re: Geotechnical Response to City Comments
 Proposed Residential Building
 2458 Cleroux Crescent - Ottawa
to: Melmar Group – Mr. Marc Nakhle – info@melmargroup.ca
date: July 20, 2023
file: PG5973-MEMO.01

Paterson Group Inc. (Paterson) prepared the current memorandum to provide responses to the geotechnical-related City of Ottawa comments. The following memorandum should be read in conjunction with the current Geotechnical Investigation Report (Paterson Group Report PG5973-1 Revision 1, dated April 1, 2022).

Services & Grading Plan

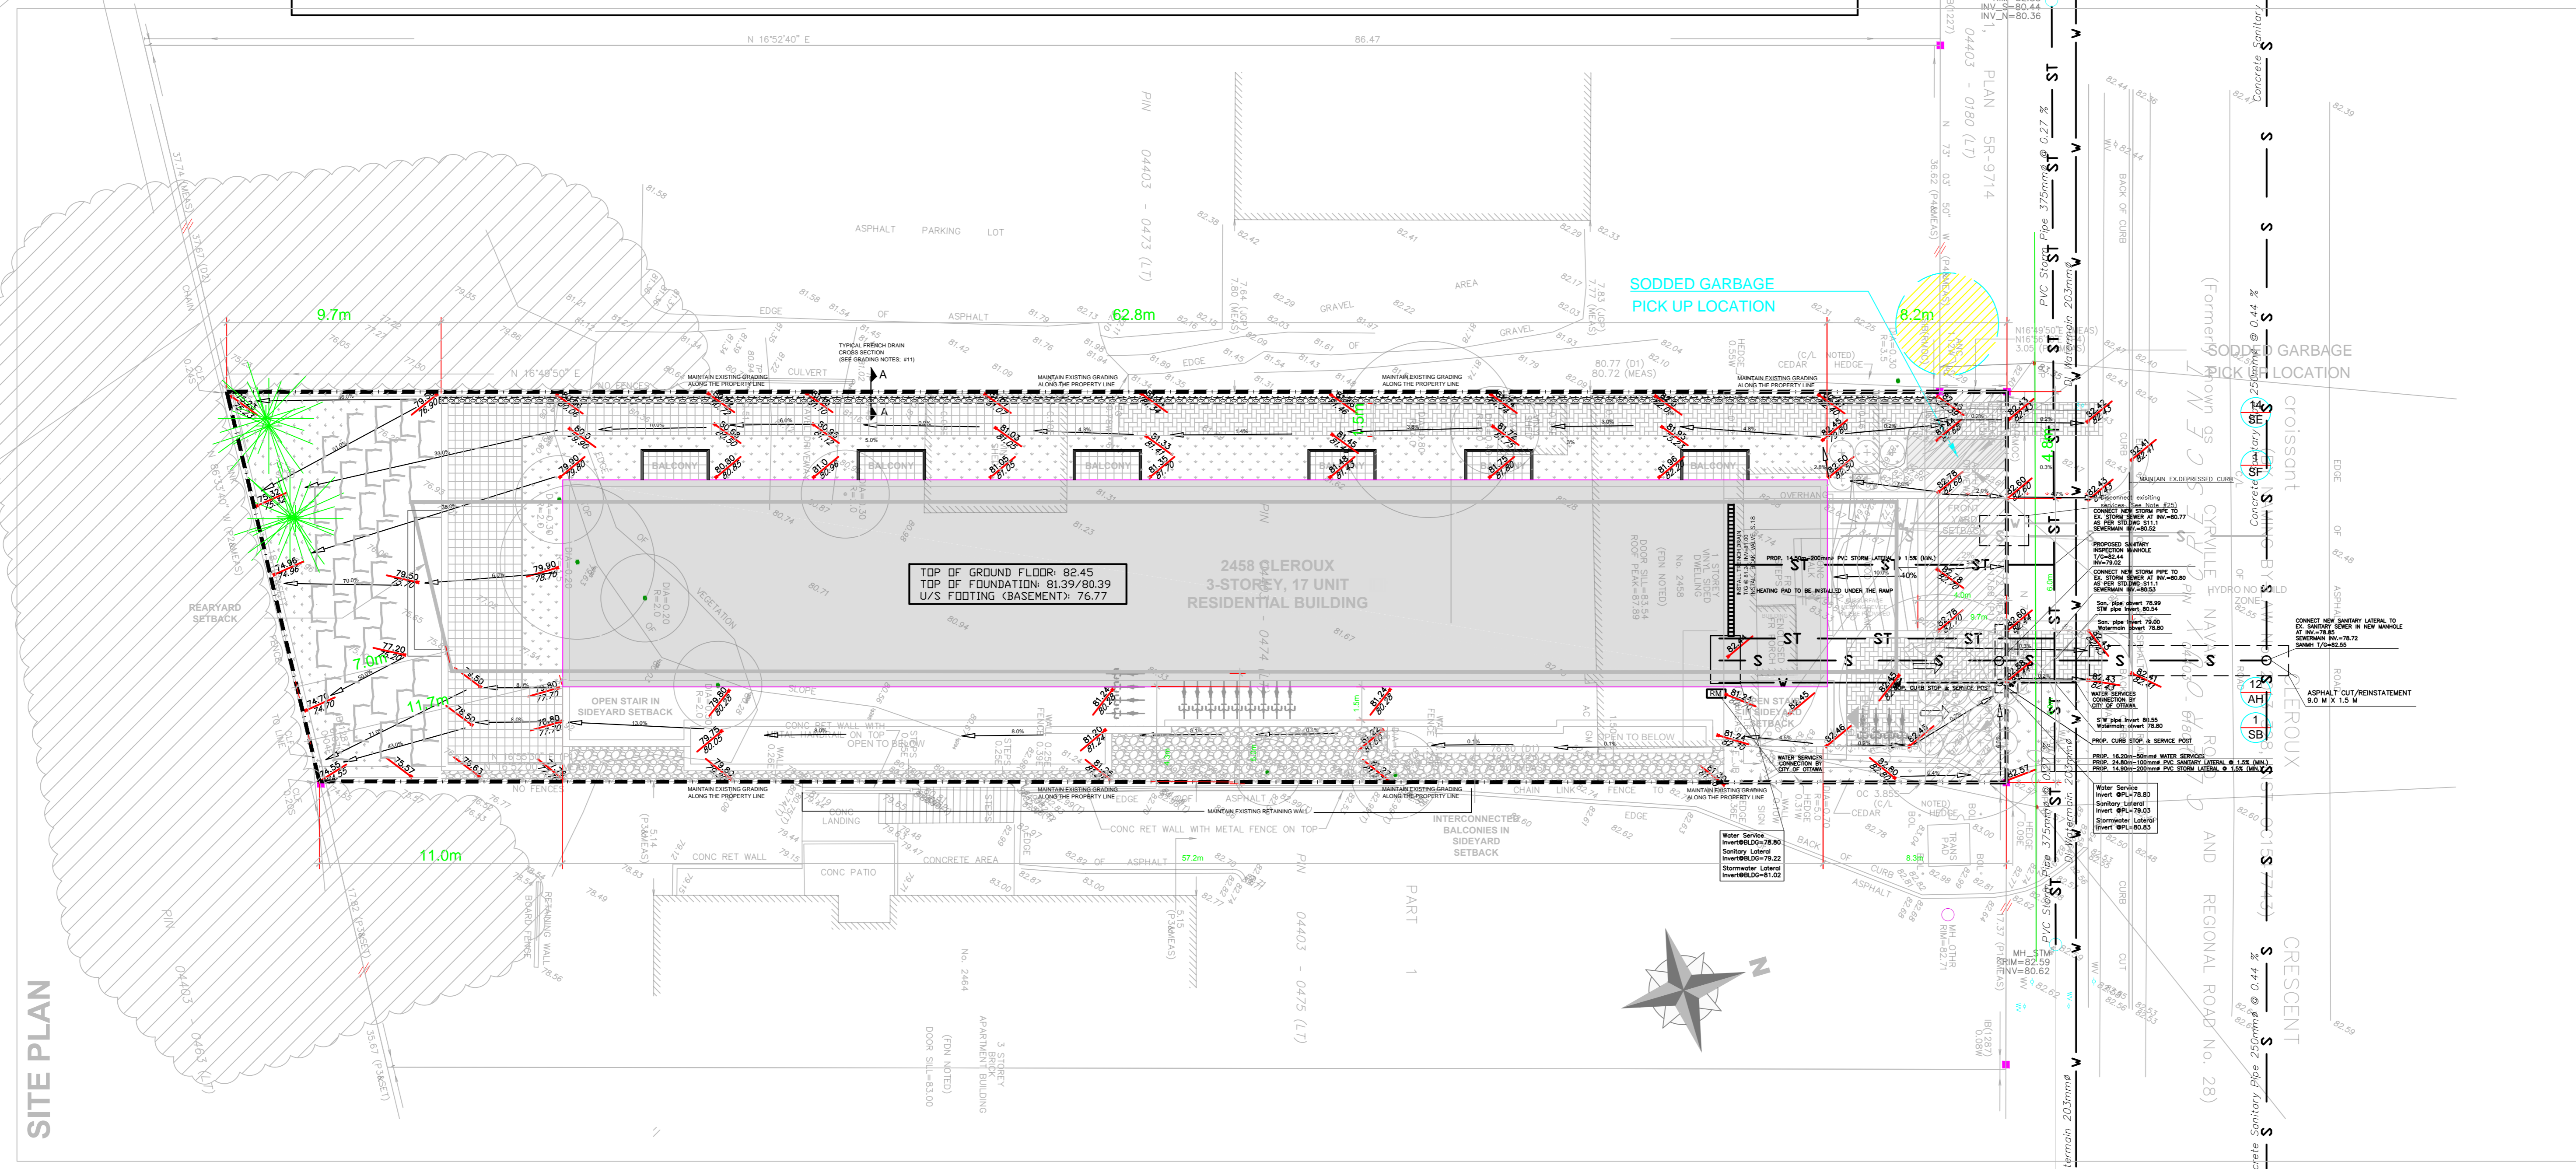
Comment 1: *Provide a geotechnical memorandum confirming that the Grading and Servicing Plan for the proposed development has been reviewed and is in accordance with the recommendations in this report. Include any further recommendations in the memo.*

Response: Reference should be made to Paterson Group Memo PG5973-MEMO.02, dated June 30, 2023, which documents our review of the latest site servicing and grading plans (Revision 1 dated February 2023) for the subject site prepared by ARCH-NOVA Desing Inc.

In summary, the proposed grading at the subject site has been reviewed and is generally considered acceptable from a geotechnical perspective. Based on our review, grade raises throughout the parking level at the rear side of the building resulted in an exceedance in our recommendations that may be accommodated with lightweight fill (LWF). LWF has been recommended throughout this area to accommodate the proposed finished grades.

In addition, the site servicing plan has incorporated the relevant geotechnical recommendations as part of the design. Therefore, the latest site servicing plan is considered acceptable from a geotechnical perspective.

Comment 3: *A French drain is proposed at the top of the underground parking. Please provide recommendations for the top of parking level protection.*

Response: Based on our review, the recommendations provided in Section 6.1 of the current Geotechnical Investigation Report PG5973-1 Revision 1, dated April 1, 2022, would address the presence of the proposed drainage swale located above the proposed parking garage podium. However, further to this, it is recommended that waterproofing of the podium deck slab and termination of the foundation drainage board be undertaken as described in Figure 1 – Horizontal Podium Waterproofing Tie In With Foundation Drainage System attached to this memorandum.

In summary, a waterproofing membrane should be applied to the horizontal podium deck slab surface and the buried portion of the foundation wall between the podium deck slab and finished grade. It is recommended to extend this membrane vertically down the foundation wall and a minimum of 300 mm below the construction joint between the foundation wall and podium deck slab. The bottom-most endlap of the waterproofing membrane extending over the drainage board should be installed loosely against the drainage board layer. This would mitigate heat associated with welding the rubber membrane from damaging the drainage layer. The loosely installed layer of membrane should extend below a minimum of 300 mm below the top endlap of the drainage board layer.

Reference should be made to Figure 1 – Horizontal Podium Waterproofing Tie In With Foundation Drainage System attached to the current memorandum for further clarification of the above-noted recommendations. Further, the above-noted items should be reviewed at the time of construction by Paterson personnel.
